APPROVED
United Building only review. Permit holder responsible for full compliance with the code.

ROOF & FLOOR TRUSSES & BEAMS

Truss Placement Plan
 SCALE: 1/4" = 1' 0"

BUILDER	CASH	CITY / CO.	ADDRESS	MODEL	DATE REV.	DRAWN BY	SALES REP.
	J. A. Hart	Sanford / Lee	1606 Hoover Rd.	Model	/ /	Sales Area	Bob Lewis
JOB NAME	PLAN	SEAL DATE	QUOTE #	JOB #			
Ryan & Emily McNeil	Plan	Seal Date	Quote #	J0821-4934

**1st FLOOR PLAN**  
 10'-0" Ceiling  
 Scale: 1/4" = 1'-0"  
 Pre-Engineered Wood Floor Trusses To Be Designed  
 By Supplier

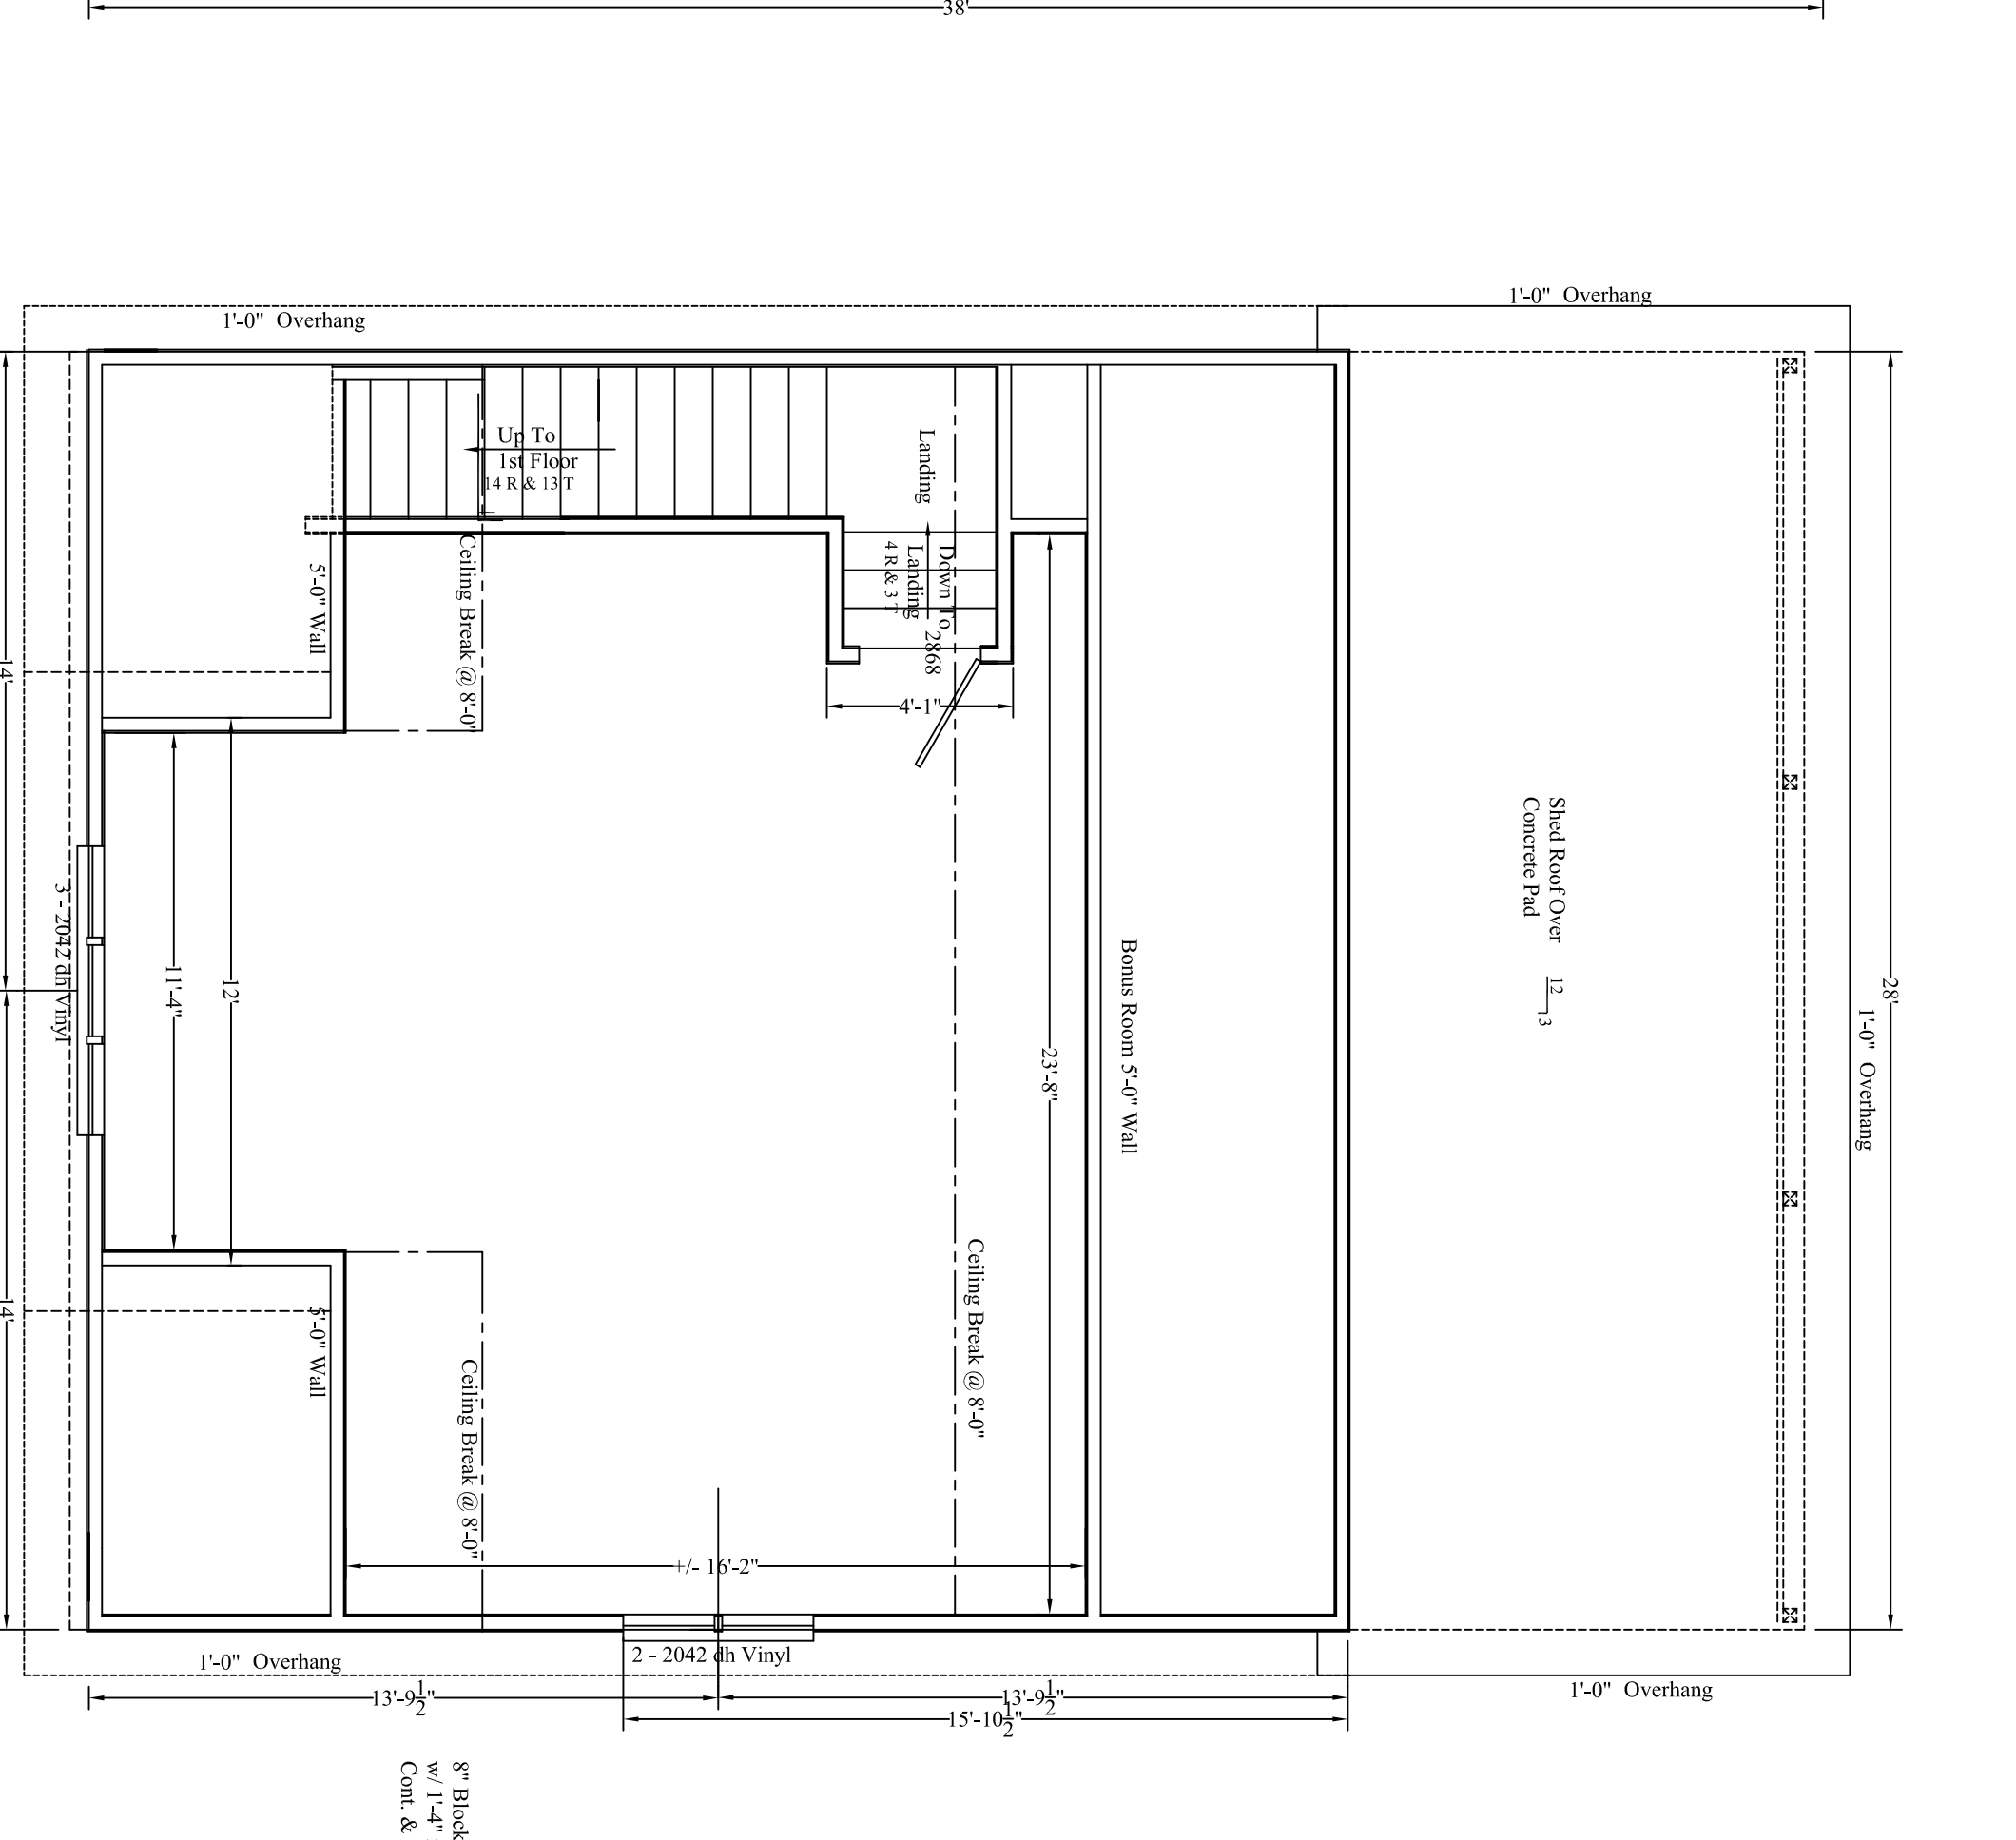
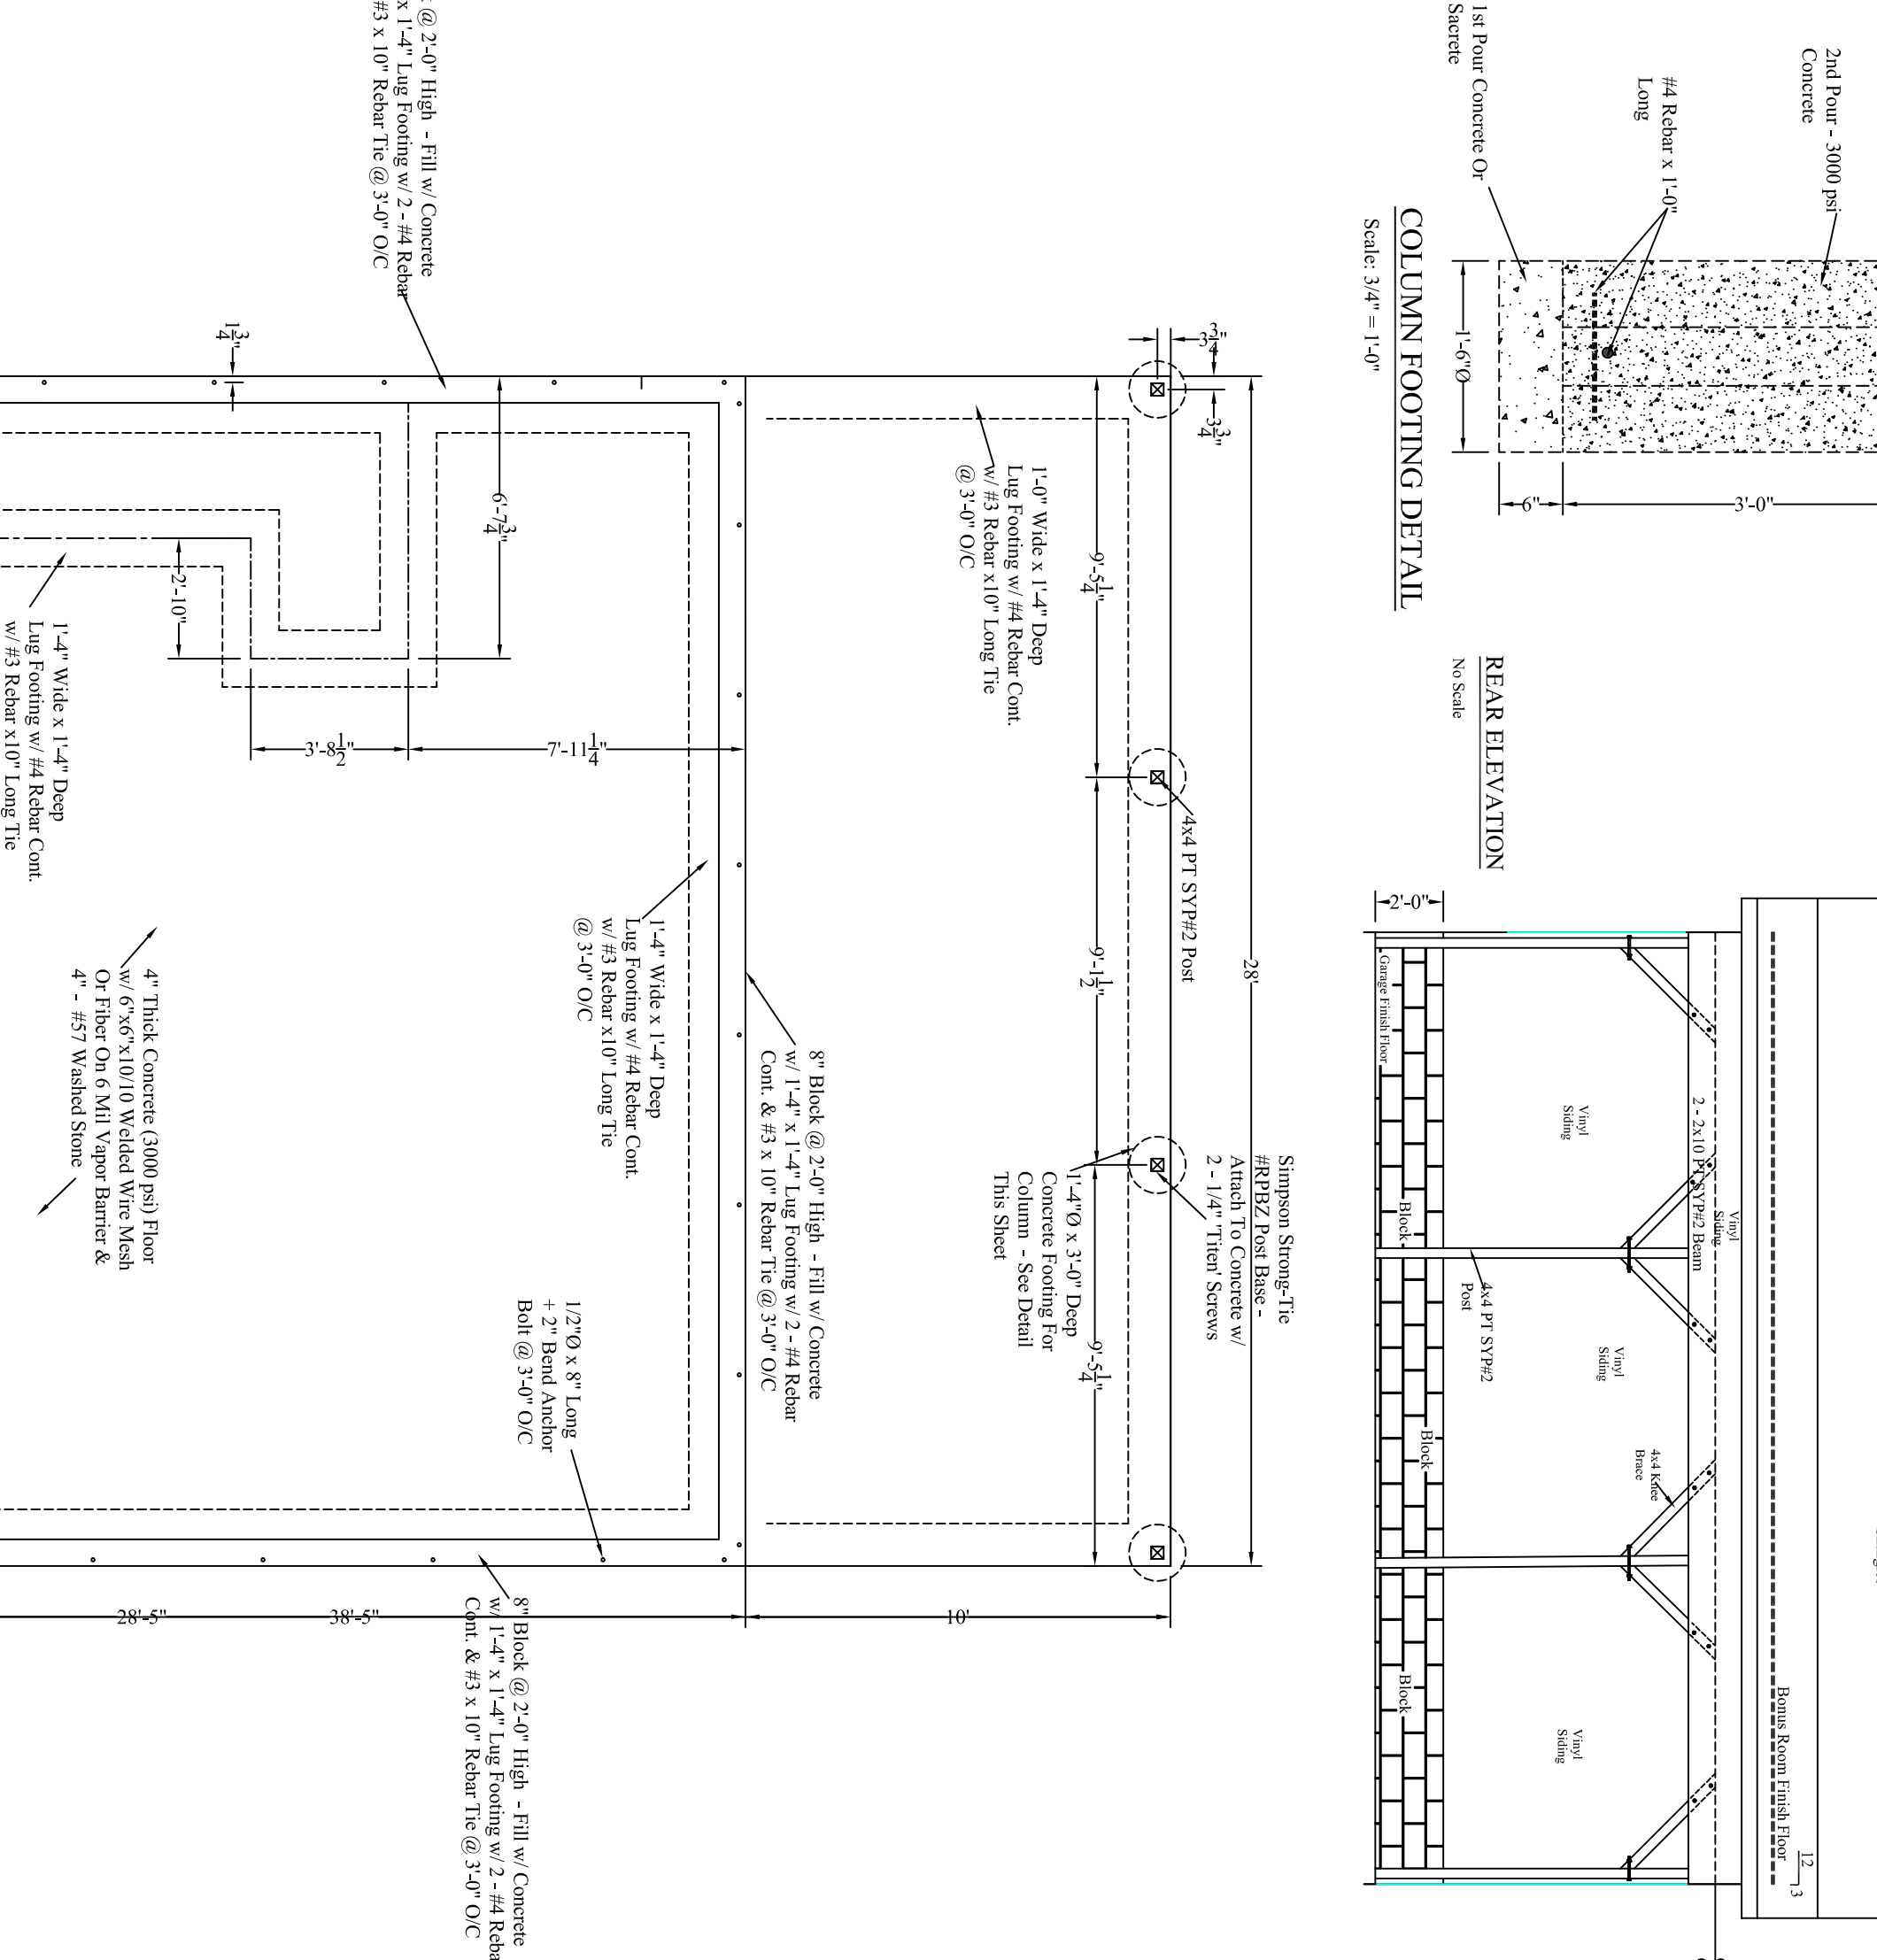
At least one of these windows must meet egress requirement.
